Submission to Application SSD 6334 Sutton Forest Quarry Project

Re: Environmental Advice Regarding a Proposed Quarry Located in the Vicinity of the Groundwater Source at 'Tennyson Park', Hanging Rock Road, Sutton Forest, New South Wales

Proposed Final Design

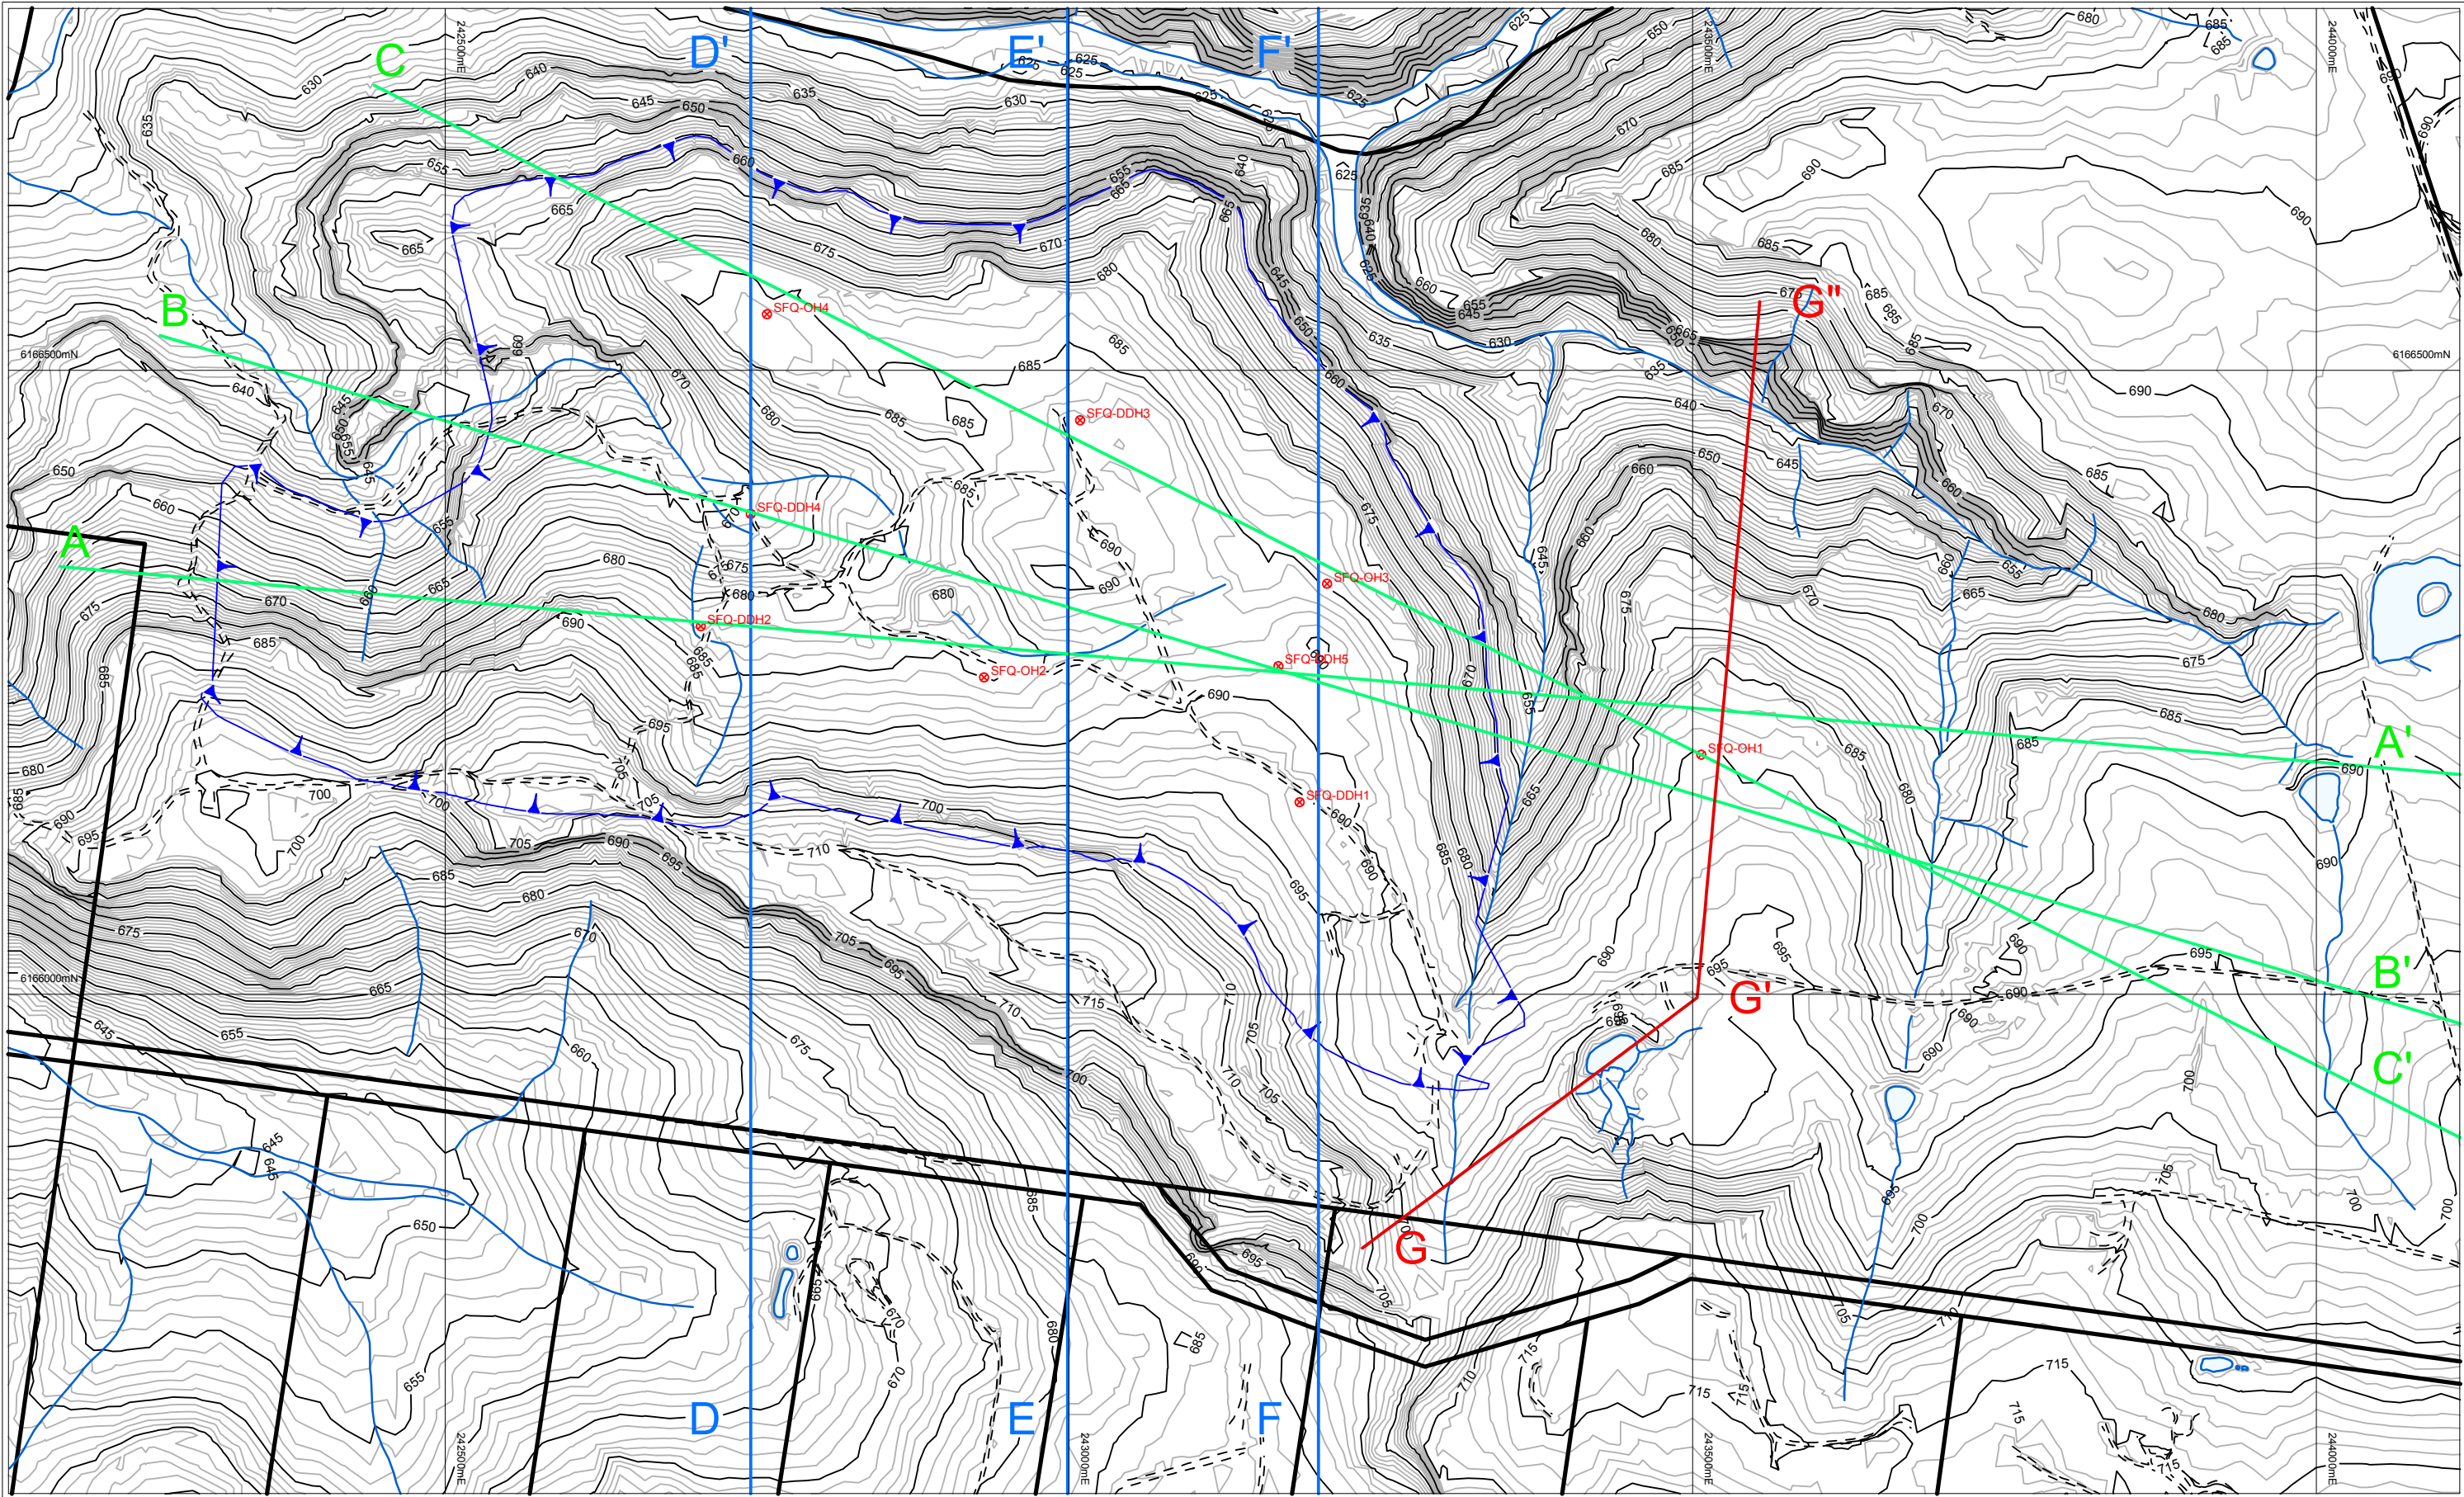
1. Hydrological impacts relating from dewatering; and
2. The requirements (proposed or required) at the end of the life of the quarry project or its earlier prolonged cessation or termination as they relate to:
 - a. The practical and financial ability to source the required 9,700,000 cubic metres of fill;
 - b. Such sourced fill material is independently supervised and validated and purely VENM or ENM quality required; and
 - c. Potential future contamination of the regional aquifer given the contents of future fill, the fill being of different composition to the existing surrounds and placement method risk.

| Aspect | Risk | Recommendation |
|--|--|---|
| <p>The proposed quarry is proposed to be filled with VENM or ENM for rehabilitation purposes</p> | <p>In view of the volume of the quarry void of 9.7 million m³, VENM or ENM will need to be sourced from thousands of source sites.</p> <p>The VENM or ENM is unlikely to come from a single homogenous site/source. In view of this, it is likely that the VENM or ENM will need to be sourced from a significant number of source sites. Due to the likely number of source sites, there is a heightened potential for contaminated material to be disposed of at the proposed quarry.</p> | <ul style="list-style-type: none"> A comprehensive and robust environmental management system will be required to ensure that the material deposited within the quarry void as part of rehabilitation is VENM or ENM. This should be developed in accordance with NSW EPA guidance for VENM classification and include the following requirements for any site from which VENM or ENM is proposed to be imported: |

| Aspect | Risk | Recommendation |
|--|---|--|
| <p>Potential for 'mounding' of groundwater within backfill of proposed quarry.</p> | <p>The backfill of the proposed quarry may be more permeable than surrounding strata, resulting in the localised 'mounding' of groundwater within the quarry void (as a result of surface water and groundwater ingress). This may increase the risk of contamination of the regional aquifer where contamination or naturally elevated constituents are present in the VENM backfill or quarry void may be mobilised by water infiltrating the material.</p> | <ul style="list-style-type: none"> • It must be ensured that the proposed quarry is backfilled with suitably low permeable material, at a compaction rate and moisture content which minimises infiltration into the void backfill post filling. |
